12th August 2024

M5 Junction 10 Improvements Scheme

Notification of Applicant's Intention to Submit Request for Proposed Changes to the DCO Application

Figure 2-14 Location of existing and proposed TS

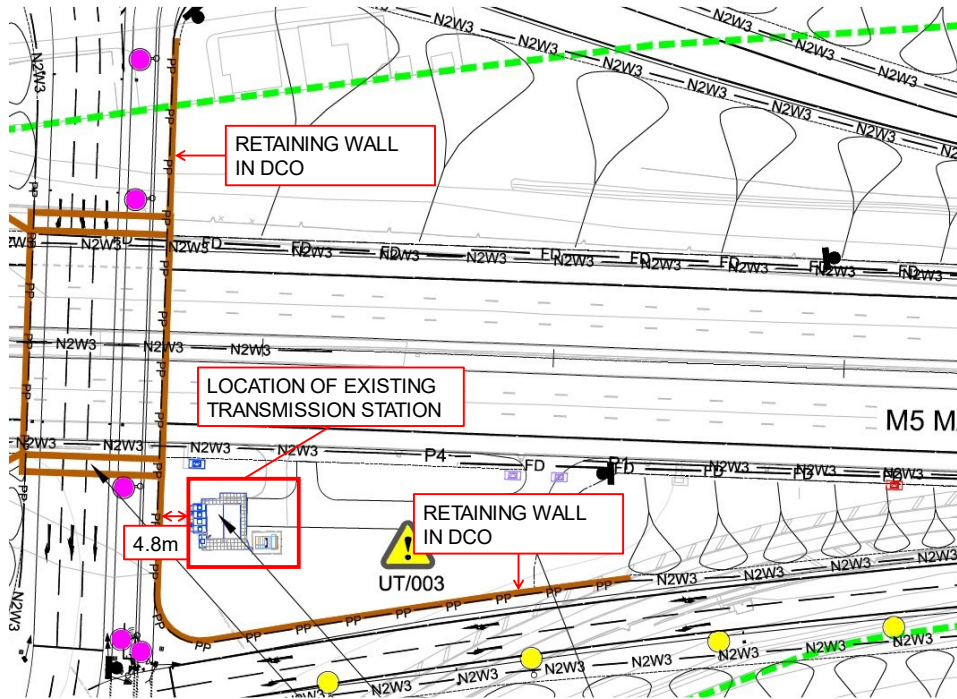
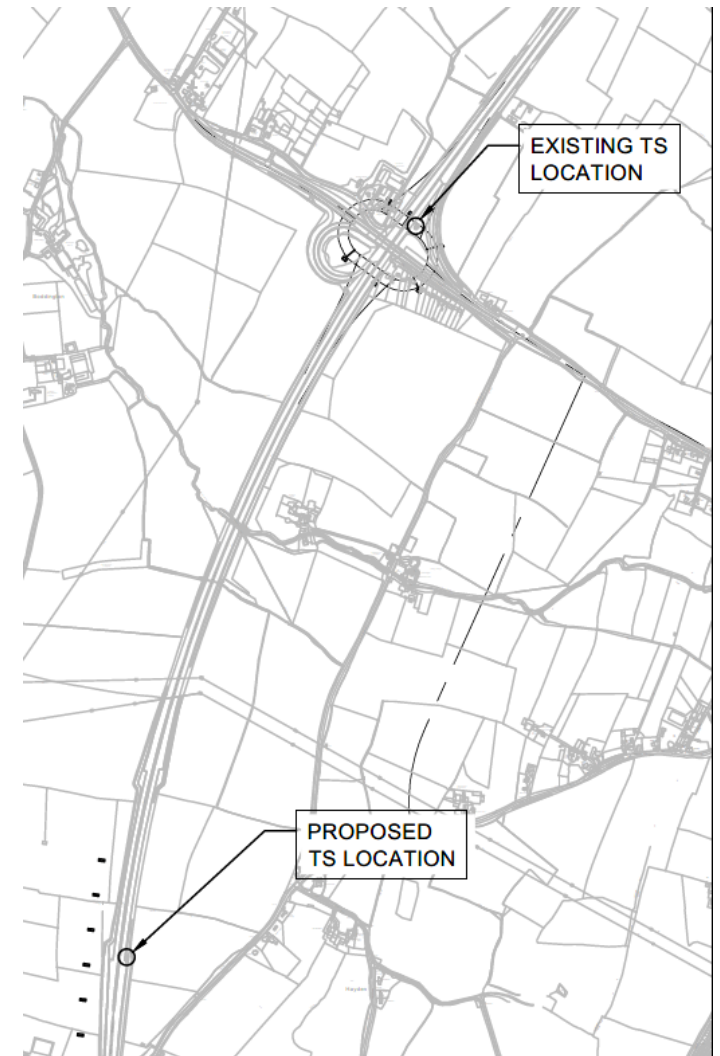
- 13.11 This change proposes to relocate the Uckington NRTS Transmission Station from its existing position in the northeast quadrant of the M5 junction 10, to a location 2.6km further south on the M5, within the highways boundary and DCO red line boundary.
- 13.12 This change eliminates the health and safety risks associated with the construction of the retaining wall in close proximity to the Transmission Station, and mitigates the risks associated with maintaining National Highways' data links during the construction period.
- 13.13 The proposed change would allow for the removal of the retaining walls for the north Piffs Elm bridge, on the north side of the east and west abutments. These would be replaced with embankments.

Figure 2-17 Plan of alternative flood storage area

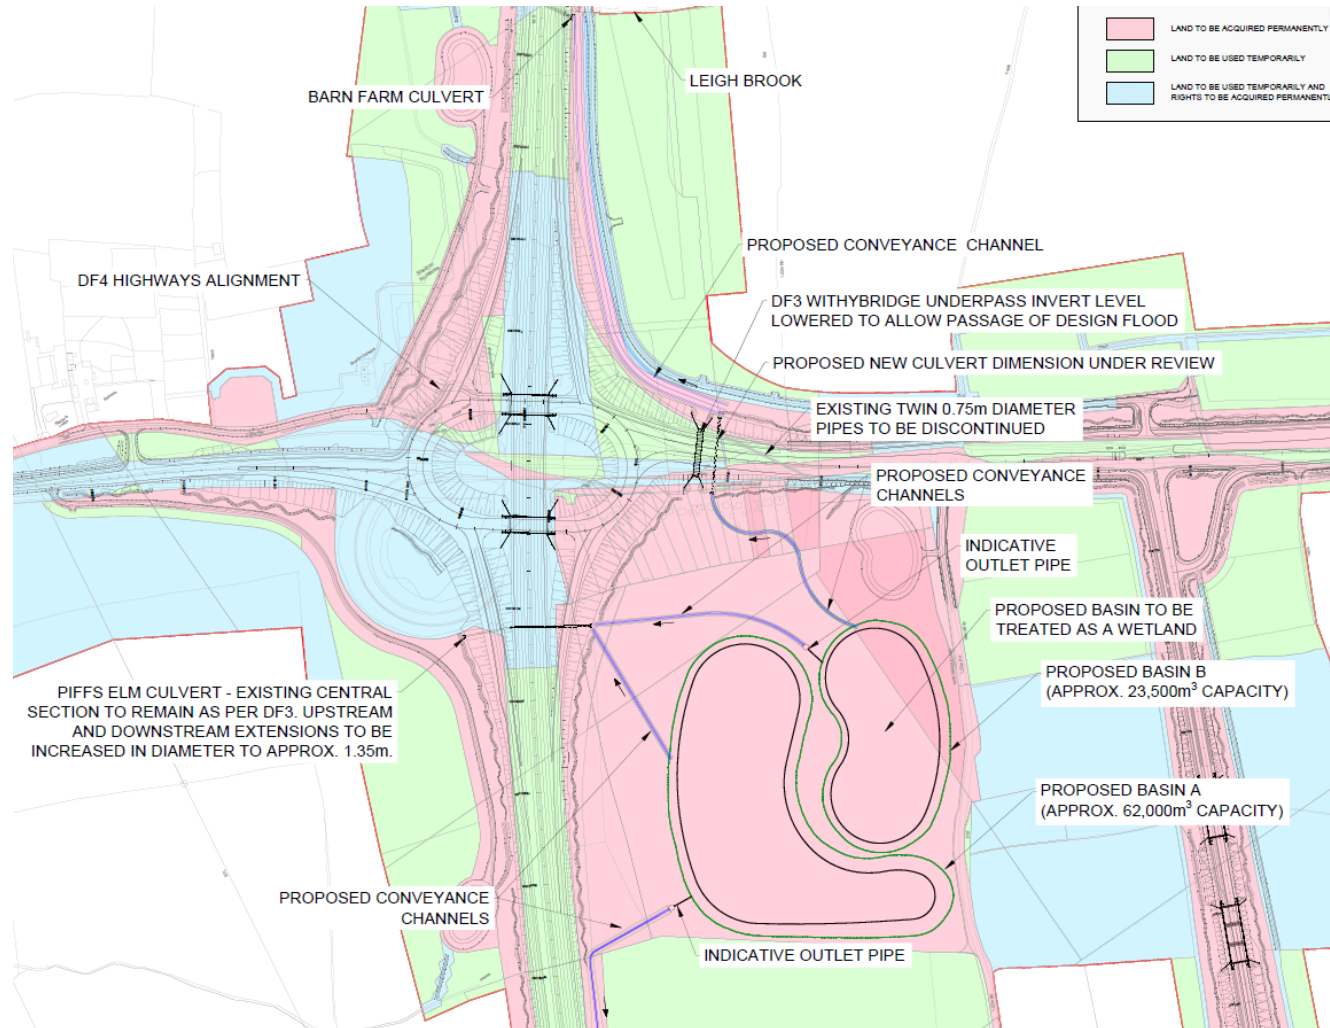
- 13.14 This change proposes to reconfigure the proposed flood storage area south-east of the Piffs Elm Interchange, between the M5 corridor, the A4109 and the Link Road.

- 13.15 Under the current Scheme the A4019 is raised to join the new gyratory at the proposed M5 Junction 10 which severs the existing overland flow path. The Withybridge Underpass invert level is set above the design flood event so would not provide flood conveyance to mitigate the severed A4019 flow path, and the existing 750mm diameter pipes that pass under the A4019 would be stopped up.

- 13.16 The DCO design states that the M5 and A4019 road embankments would act as impoundment structures and the flood compensation area would need to be registered as a large raised reservoir under the Reservoir Act. This would place onerous responsibilities on maintaining parties, and been raised as an area of significant concern by National Highways.

- 13.17 The proposed change would –
- Provide two separate basins to store 23,500m³ and 61,000m³ entirely below the current ground level, with conveyance channels to pass flood water forward under the M5 and the A4019 road embankments.

- Lower the Withybridge underpass invert level to convey flood water under the A4019.
 - Replace the existing 750mm pipes under A4019 with new culverts.

- 13.18 This would provide the benefit of minimising the maintenance responsibilities by removing the requirement to use either the M5 or the A4019 road embankments to impound the reservoir.

Figure 2-19 Cross-section, showing the yellow area to be infilled

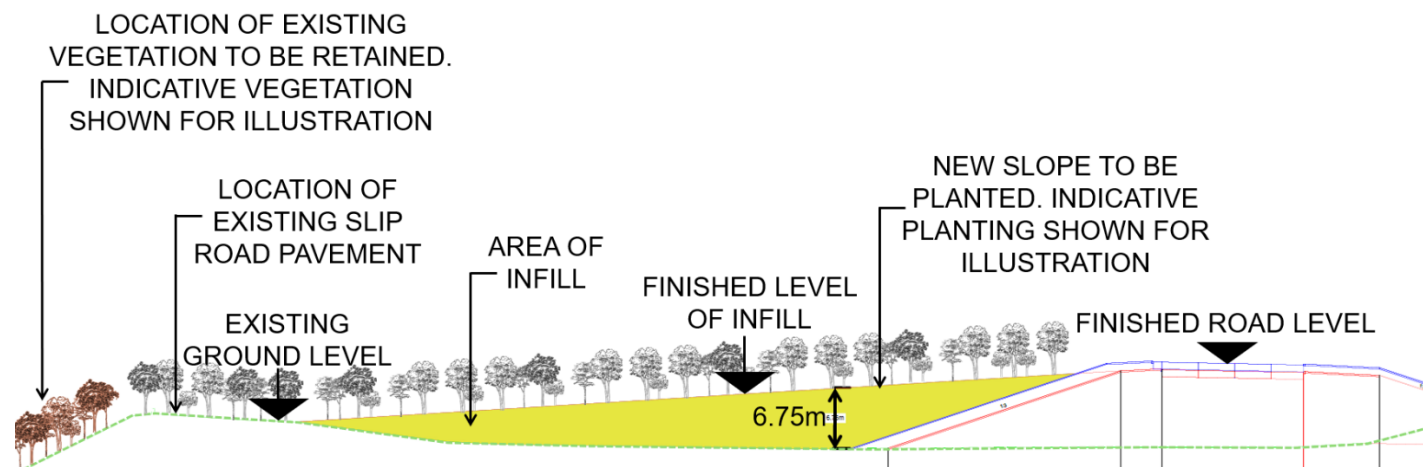
13.20 This change proposes to infill the existing M5 J10 northbound on-slip loop with site-won material which would not be suitable for re-use elsewhere, to provide improved screening of the gyratory.

13.21 The proposed change would provide a sustainable solution to managing site won materials arising from the works and create a new slope with enhanced planting opportunities.
